# IMMINGHAM EASTERN RO-RO TERMINAL

Proposed Changes Notification Report

Document Reference 10.3.2

PINS Reference – TR0300072023

Drawing number
B2429400-JAC-00-ZZ-DR-ZZ-0203

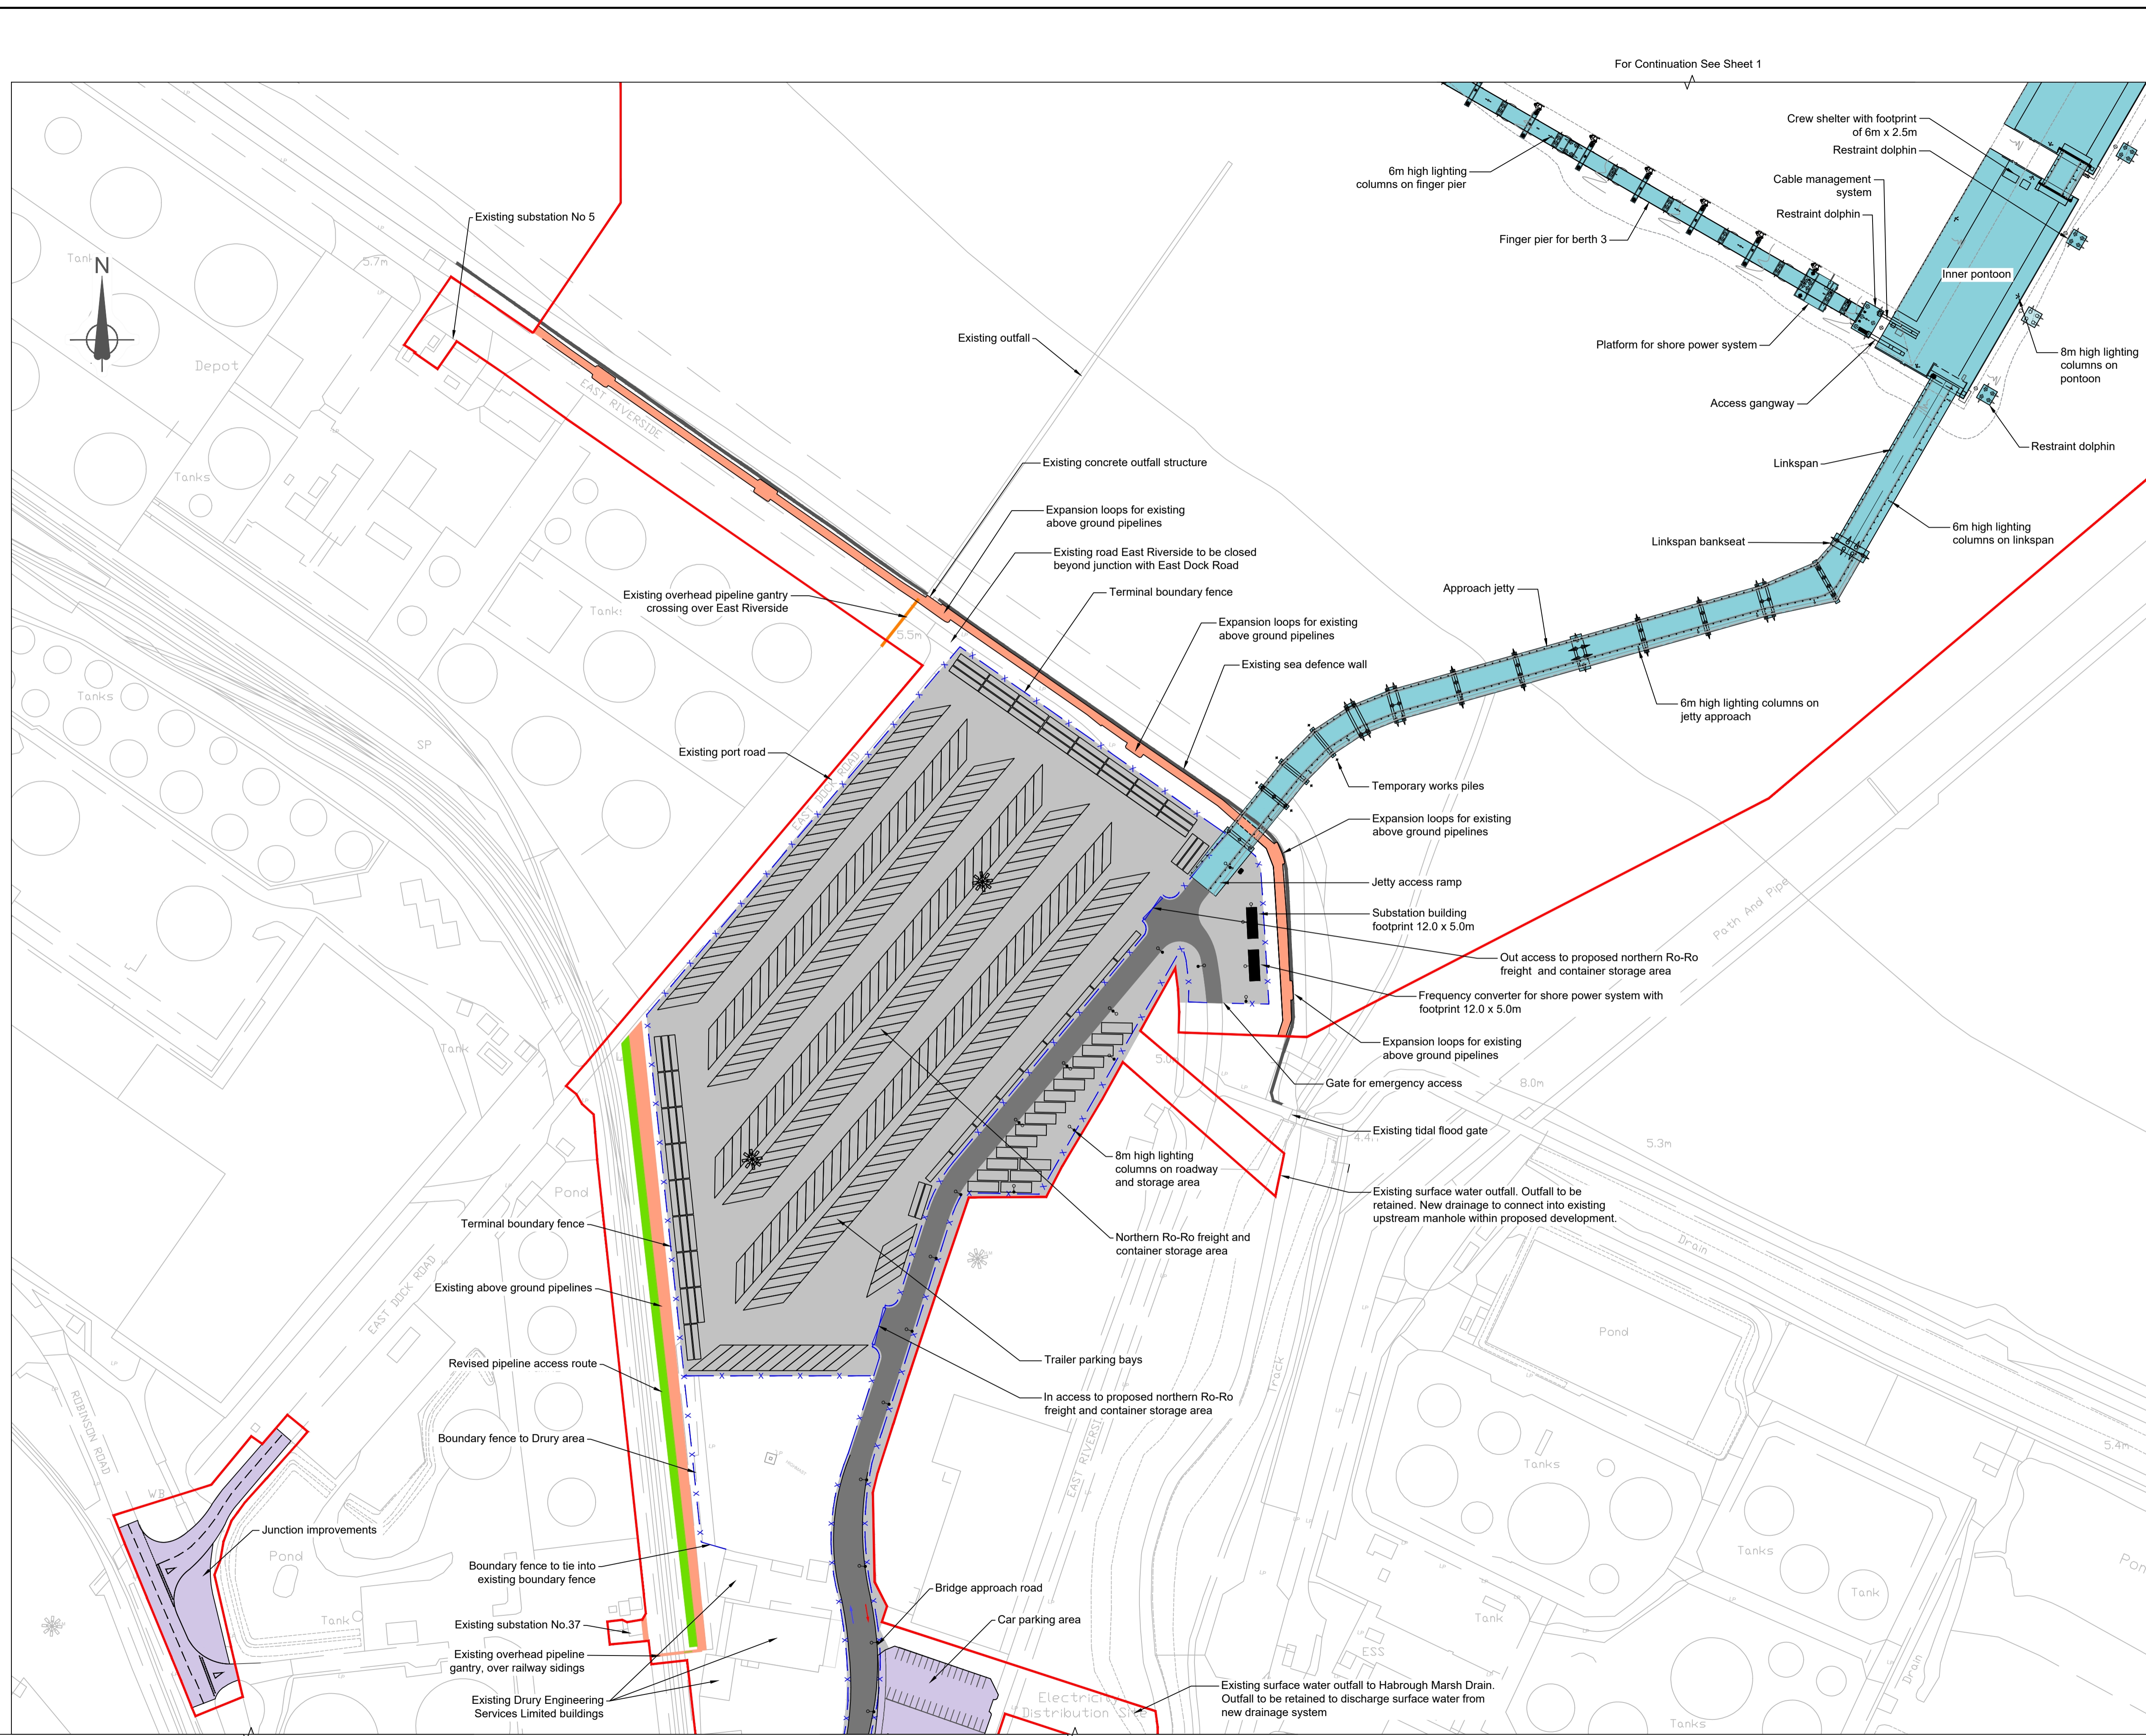
- 2.17 With a view to improving the operational efficiency of the Proposed Development's storage areas, the Applicant wishes to realign and shorten the internal bridge linking the Northern Storage Area with the Central Storage Area.

- 2.19 The proposals as submitted as part of the February 2023 DCO application would have taken the southern line of the bridge across the ABP internal railway line and some distance into the Central Storage Area. By shortening the length of the bridge an area of land within the Central Storage Area previously not available for use can be brought into use.

- 2.20 The change affects the originally submitted plans in that to bring the bridge down safely before ABP's internal railway line, it will be necessary to amend the originally identified limits of deviation.

- 2.21 Figures 3 and 4 below show how the originally submitted scheme would be amended if this proposed Change 2 is accepted. Further details are provided in the ES Addendum (Appendix 1) at paragraph 2.3.

Drawing number
B2429400-JAC-00-ZZ-DR-ZZ-0205

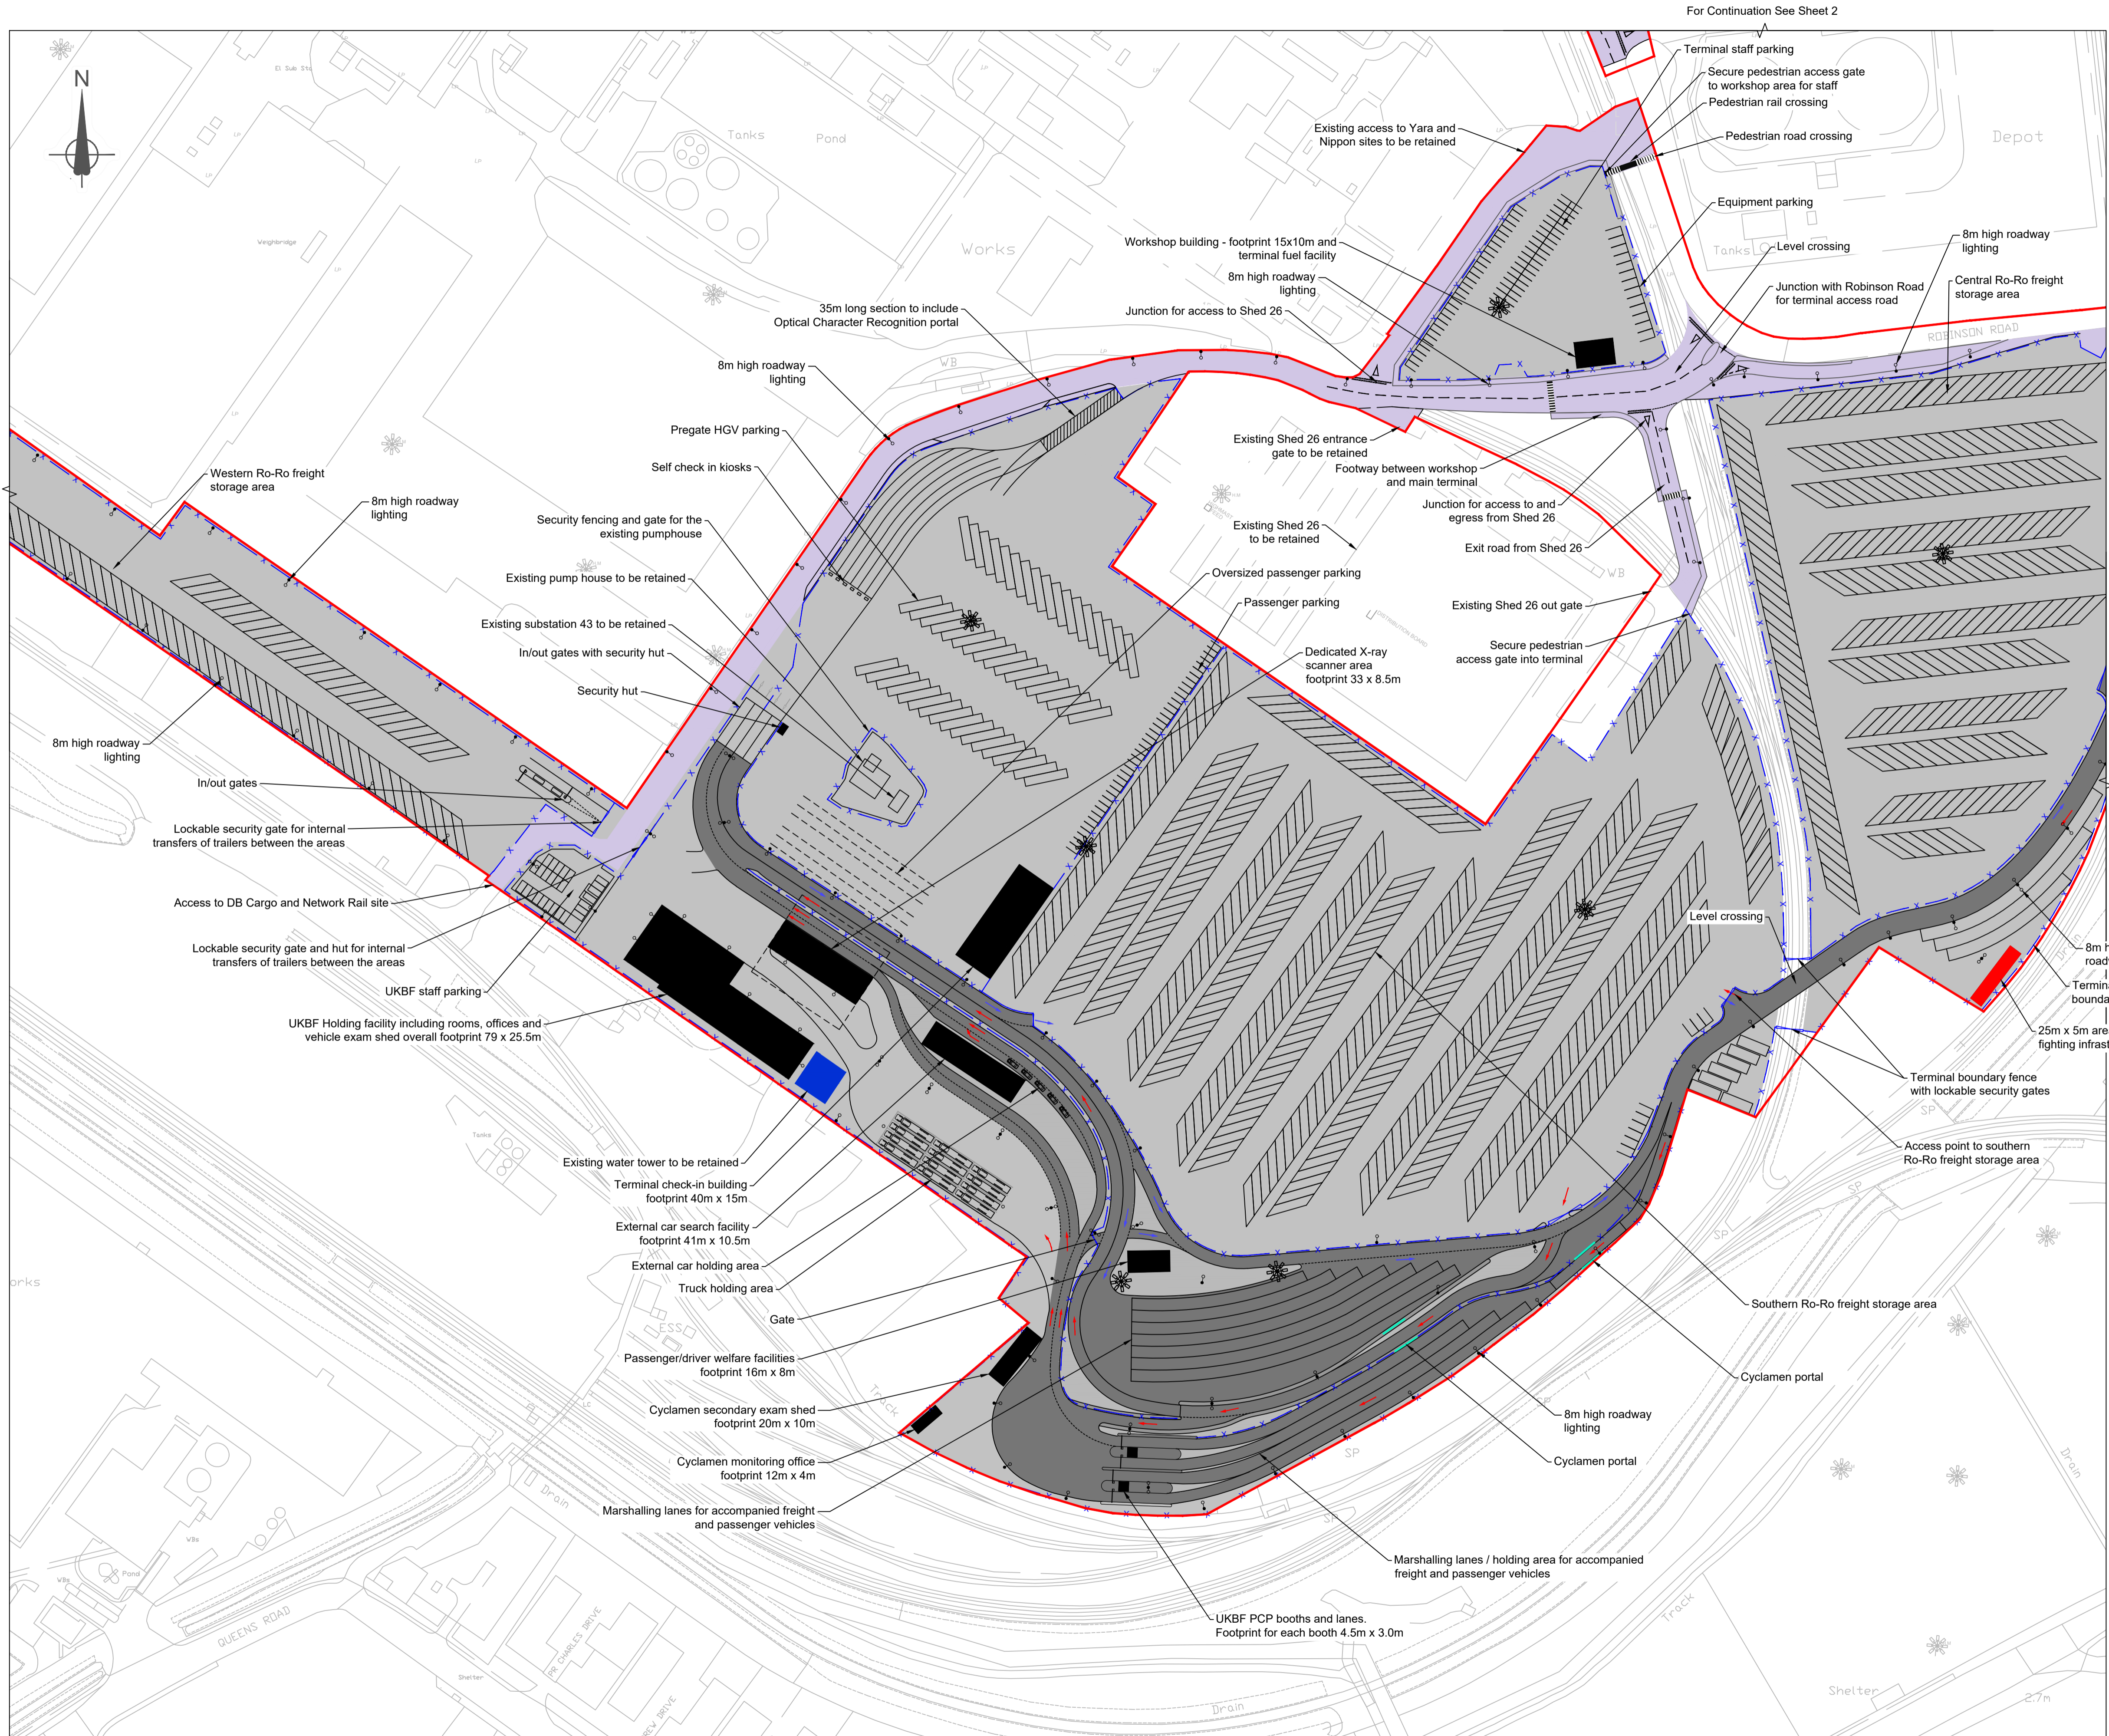
- 2.24 The area within which the UKBF facilities will be located has not changed since submission, but the general layout and the location of the facilities has changed to reflect UKBF's stated preferences.

- 2.25 In addition, in consultation with UKBF, changes are proposed to the operational layout to enhance the efficiency, safety, and security of the facility. For example, the inbound road and associated passport control booths have been moved to the southern boundary with the shift of the marshalling lanes to move slightly northwards.

- 2.26 Figures 5 and 6 below show how the originally submitted scheme would be amended if this proposed Change 3 is accepted. Further details are provided in the ES Addendum (Appendix 1) at paragraph 2.4.
